Subject: Planning application S6/2010/1710/FP - Land Adjacent Georges Fields

Response to Planning application from Hertfordshire County Council (T and CP GDP Order 1995)

Formation of visitor parking area, paths, landscaping and ancillary works

Notice is given under article 10 of the Town and Country Planning (General Development Procedure) Order 1995 that the Hertfordshire County Council as Highway Authority recommends that permission be refused for the following reasons:

DRAWING NUMBER:
 843/AC/02C

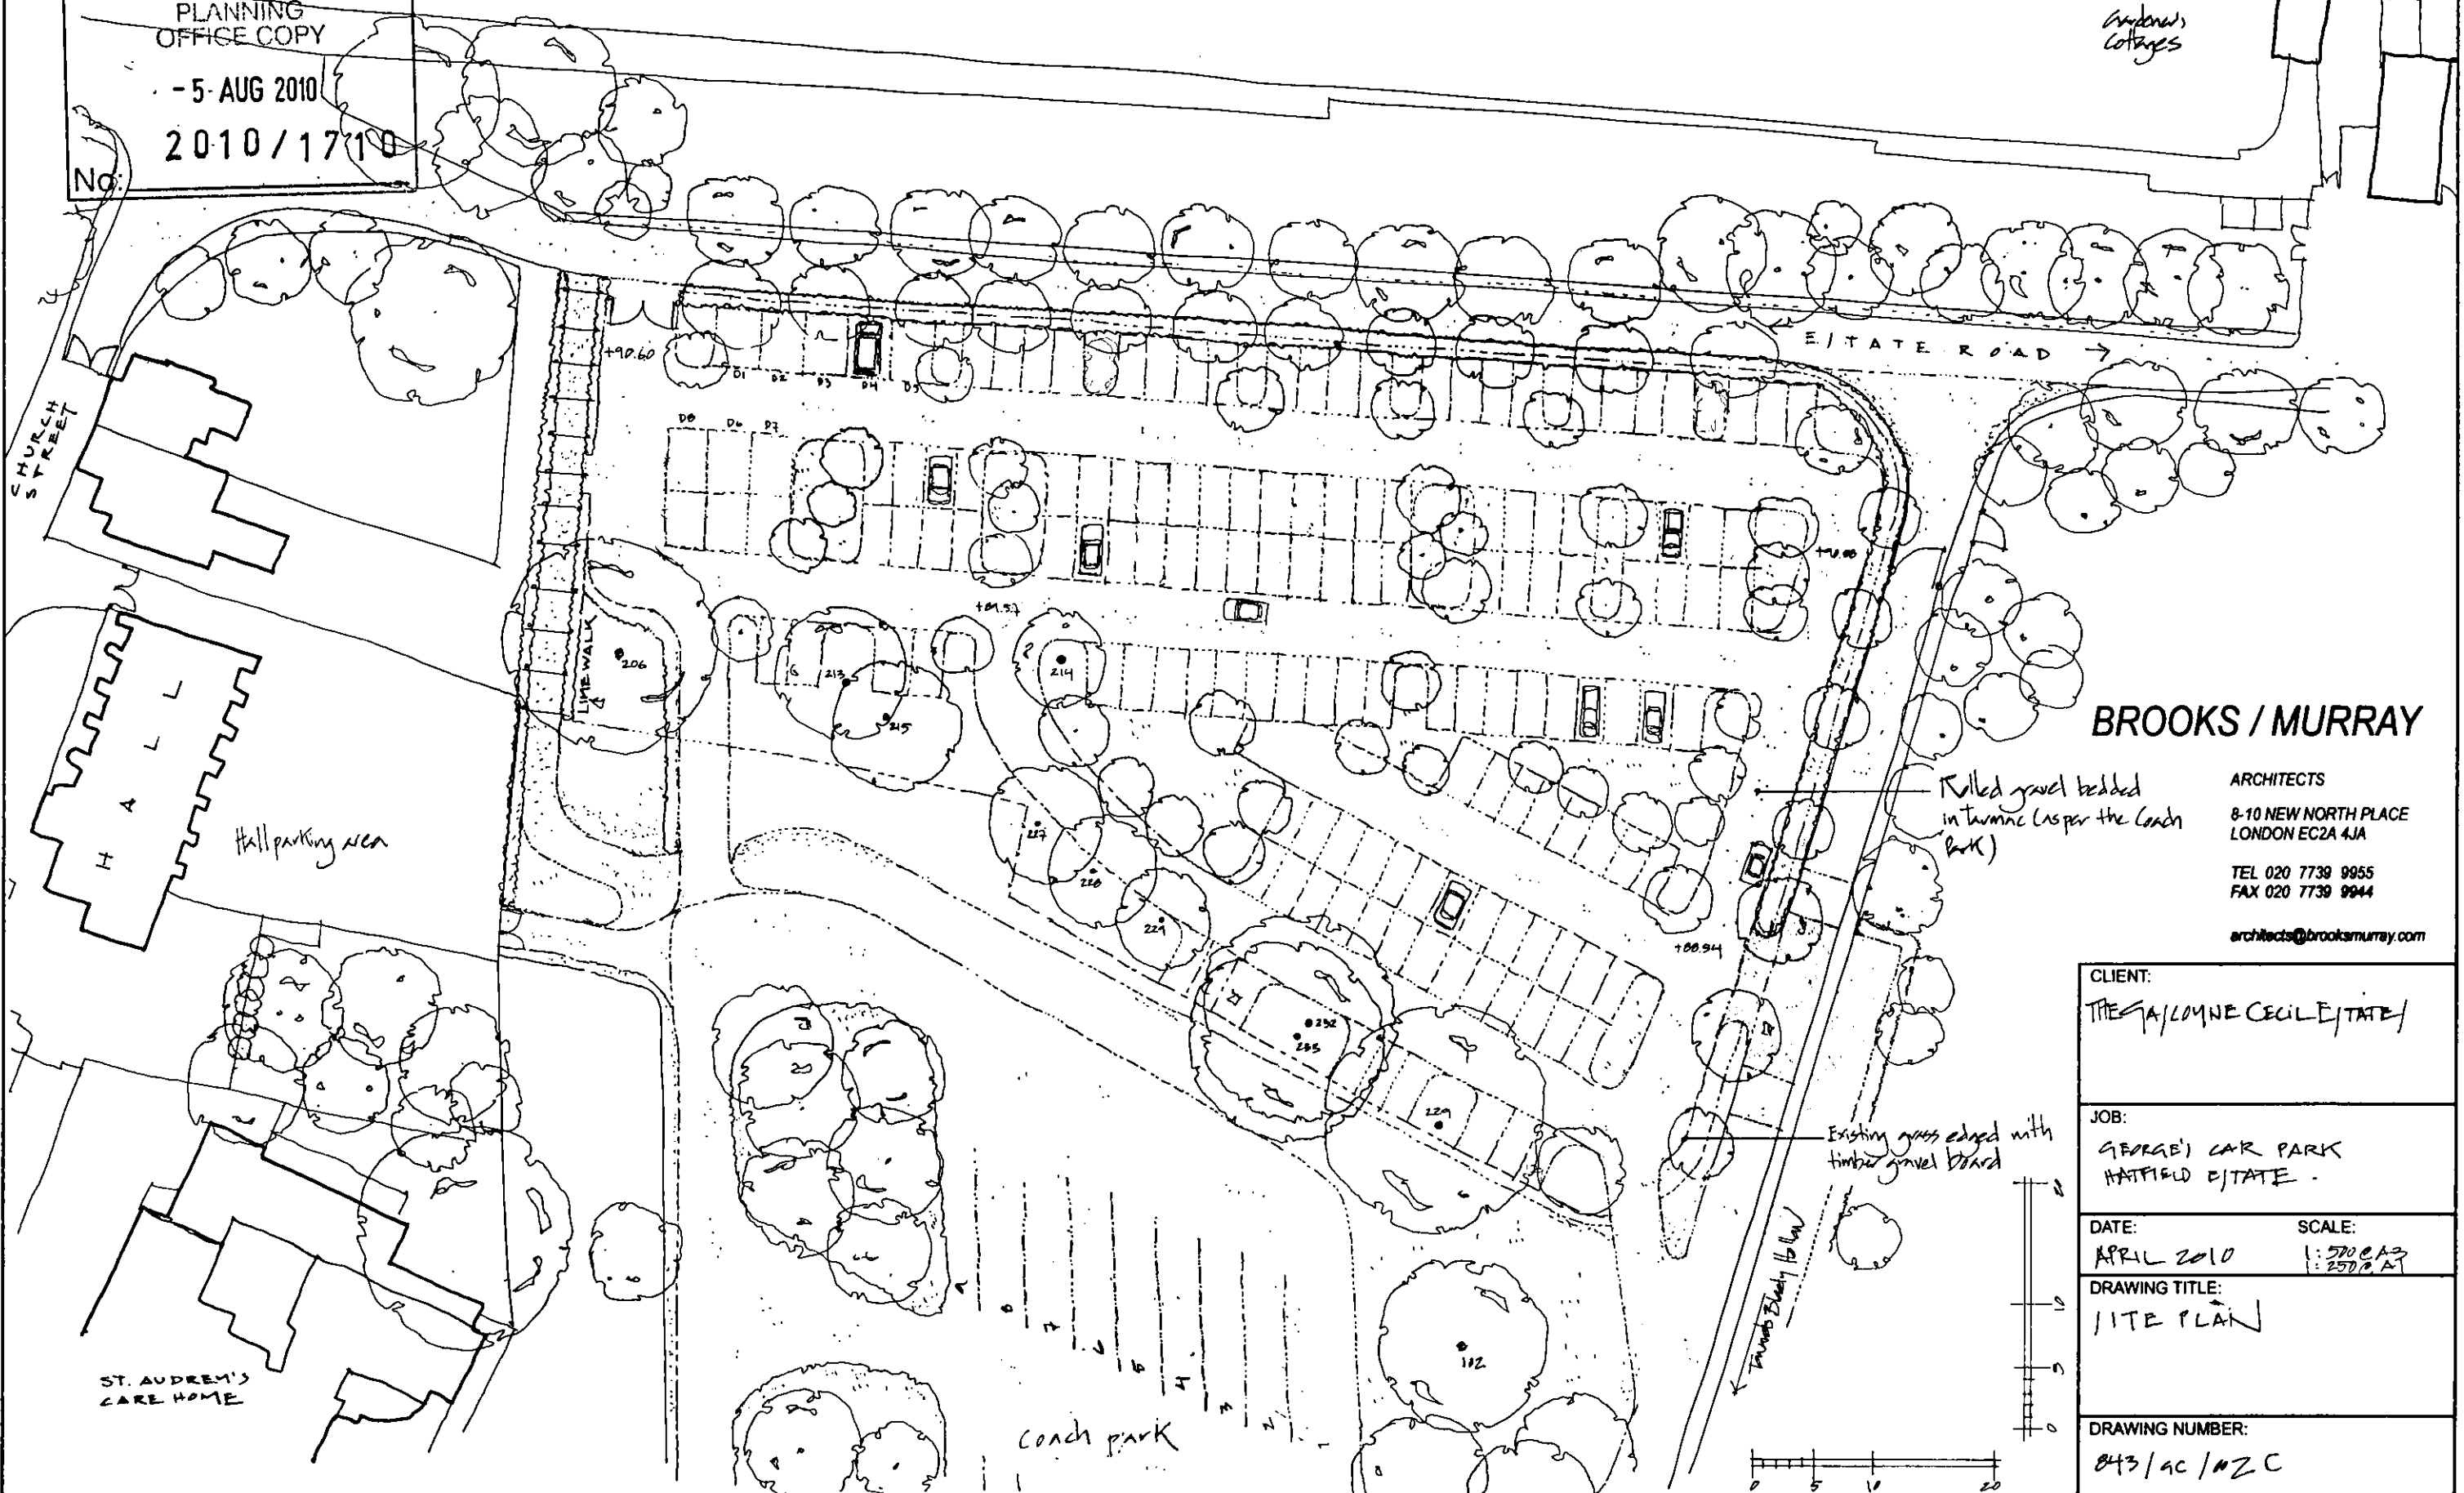
1. The development if permitted would intensify the use of an existing access on A1000 close to the roundabout junction with the B197. Would the slowing and turning of vehicles associated with the use of the access lead to further conflict and interference with the free flow of traffic on the highway and be detrimental to highway safety.
2. Whether the proposed means of exit from the site using the service road between Church Lane and The Broadway is adequate by reasons of its width and alignment to serve the proposed development with safety and convenience.

Comments The proposal is to provide a new visitor car park for 148 vehicles to replace the exiting 152 space car park currently located in front of Hatfield House. The proposed car park would be accessed from Church Lane using the entrance known as George's Gate which also serves the newly constructed 12 space coach car park. Church Lane between George's Gate and the junction with Great North Road was widened to enable it to accommodate coach traffic.

The transport statement suggests that cars wishing to travel north and west will make use of the service road that links between Church Lane and The Broadway to enable them to access the French Horn Lane/Great North Road roundabout . This service road is of one lane width and has tight radii and is not designed to accommodate large volumes of traffic. The geometry of the junction of this service road with The Broadway makes the left turn onto The Broadway difficult and may result in vehicles over-running into the lane of oncoming traffic. No tracking movement diagrams have been provided.

The proposal will result in increased numbers of left turning vehicles into Church Lane from the A1000 and left turning vehicles from Church Lane onto the A1000. This junction is close to the French Horn Lane/Great North road junction and the increased number of left turning movements will lead to the slowing of vehicles on the A1000.
